To: FILE
From: Nell Donaldson
Subject: Application ID: 2014-220
Date: 12/4/2014

Memo To: Nell Donaldson
Barbara Barhydt
From: David Margolis-Pineo
Re: Review Comments for 1210 Brighton Ave - Portland Hotels 2014-220

The Department of Public Services has the follow Development Review Comments.

Sheet Title:  
**Post Development  
Drainage Plan**

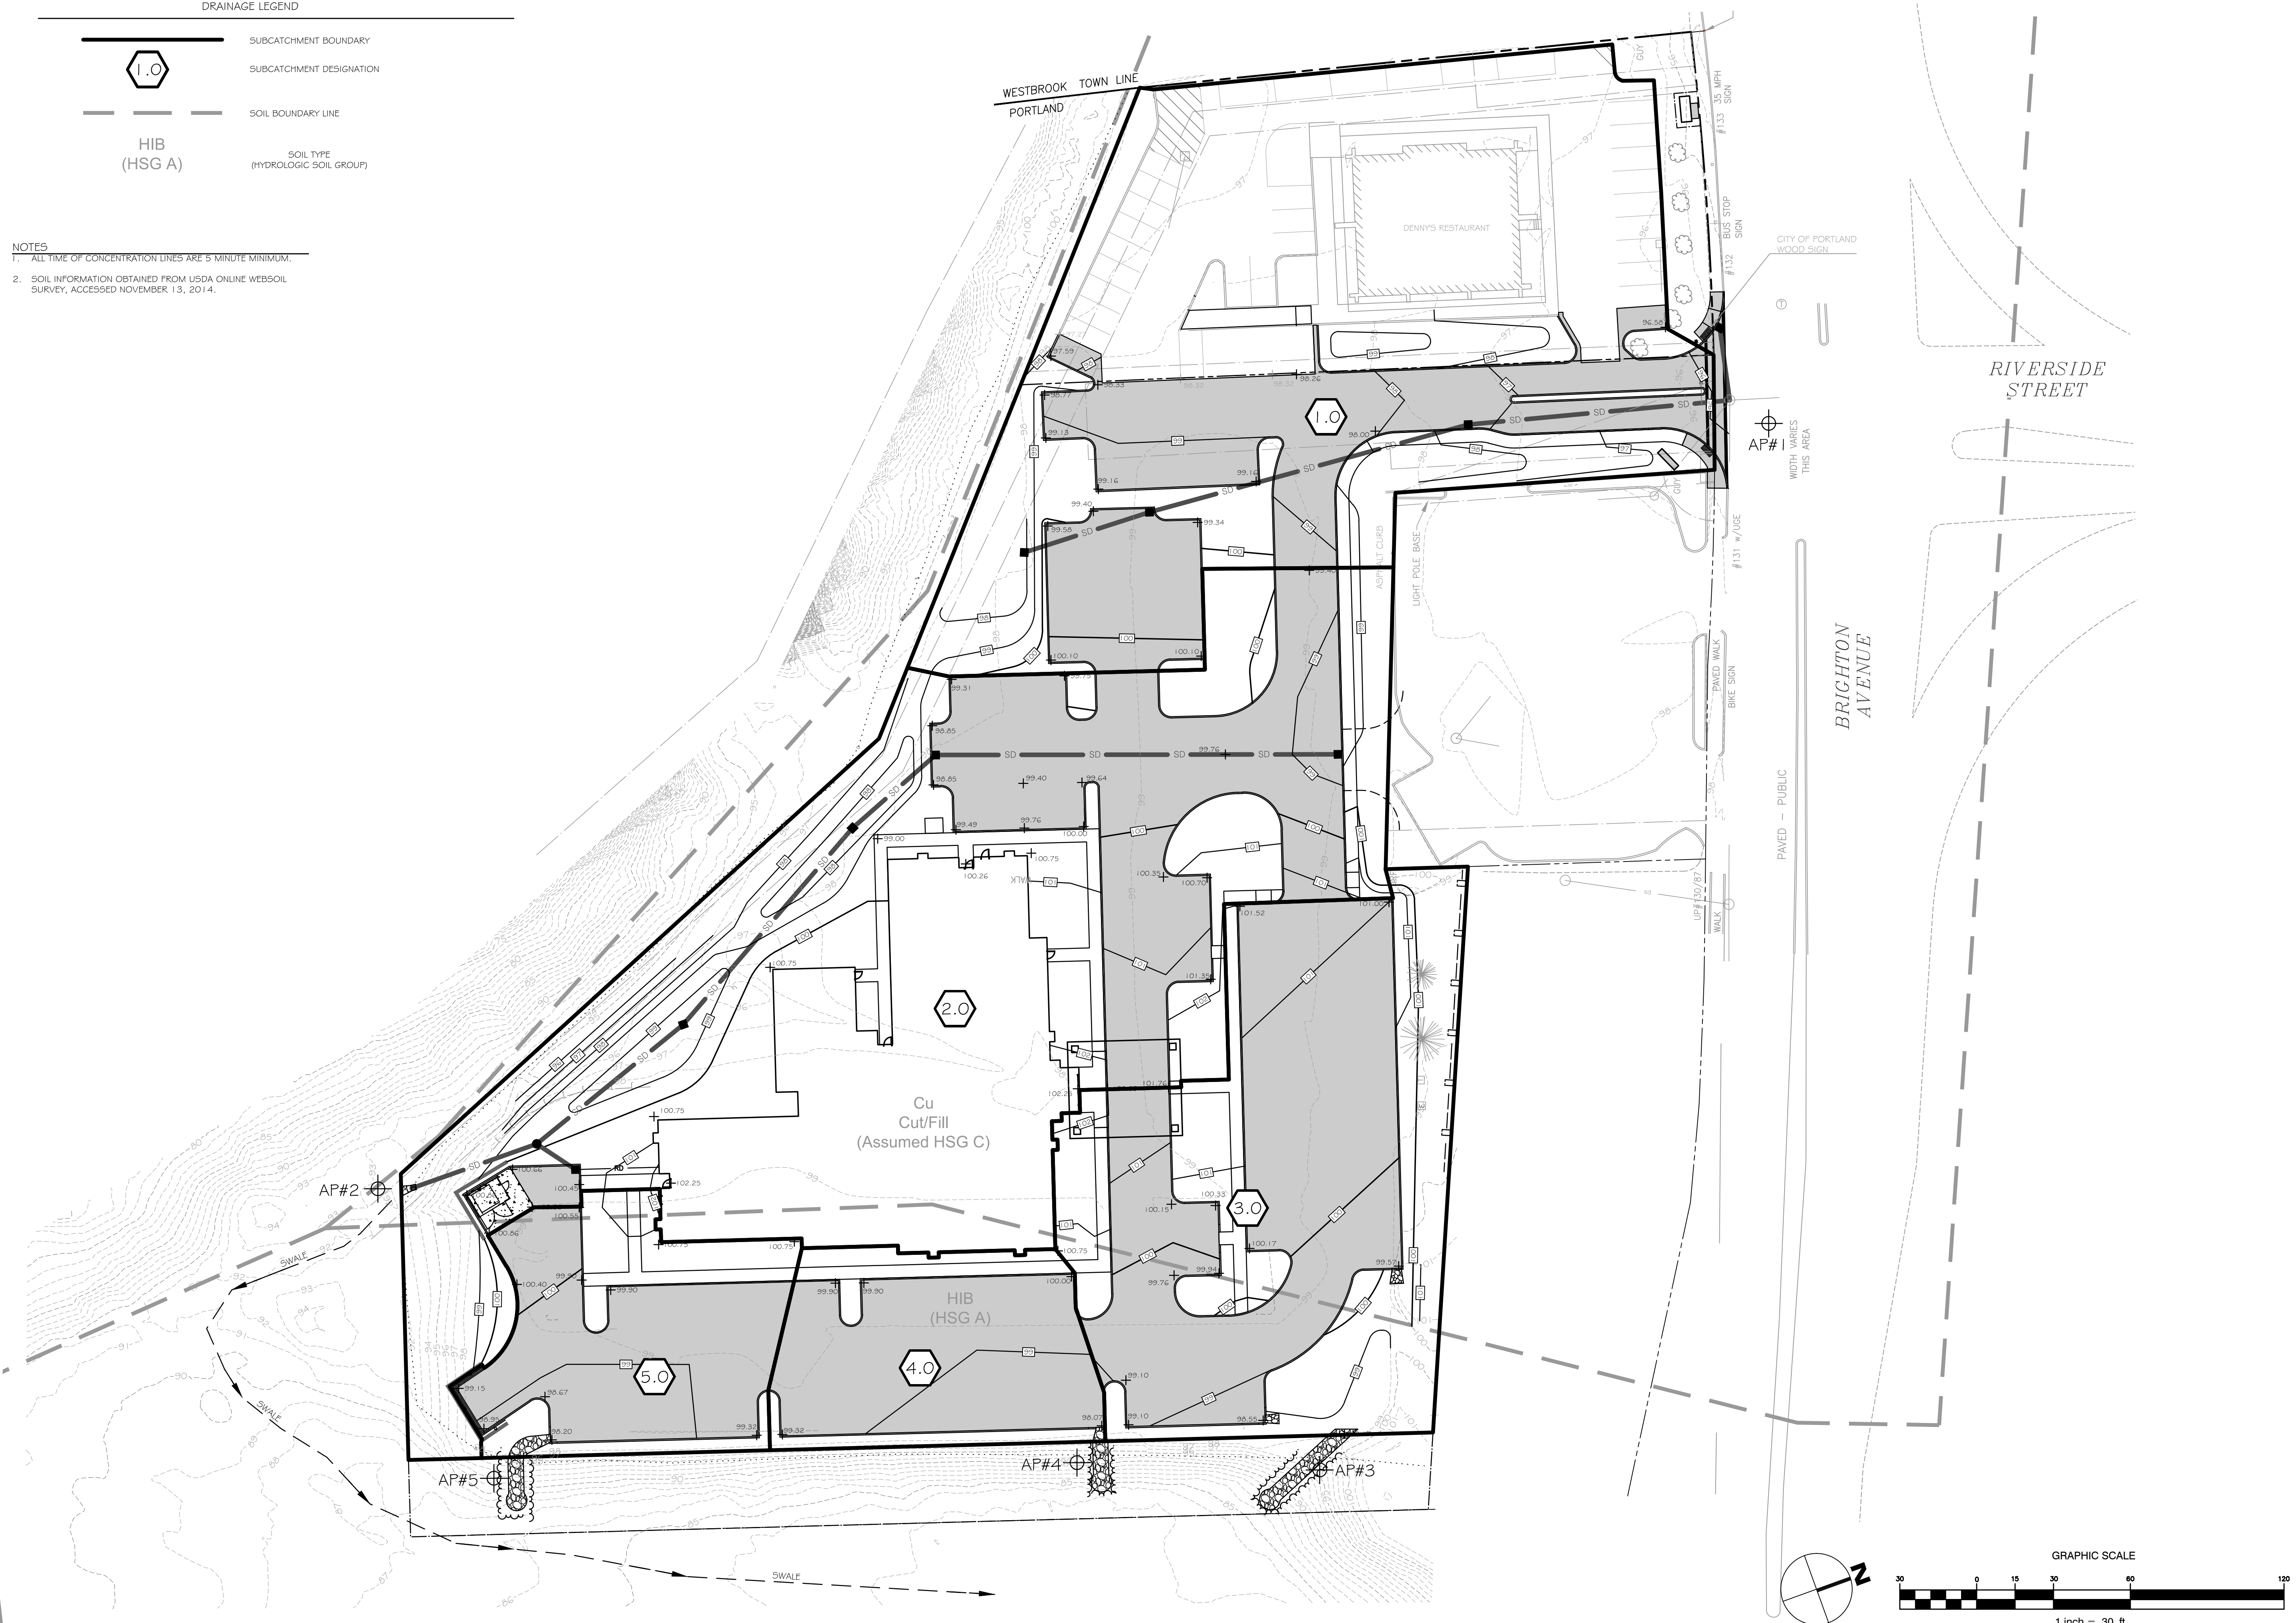
1. All proposed catch basins shall have a three foot sump per City of Portland Technical Manual standards.
2. There are several locations where site drainage is proposed to discharge on to abutting property. I am aware that the applicant is proposing to direct drainage where it already exists. Where drainage is directed towards City of Portland land the Maine Turnpike I find acceptable unless David Senu takes exception. As for the discharge onto Pike's property, I have a concern. Pike is in the process of reclaiming their pit. Once filled the intent is to redevelop this parcel. With that in mind, the applicant is requested to consider redirecting the discharge to Brighton Ave or obtain a drainage easement from Pike Industries.
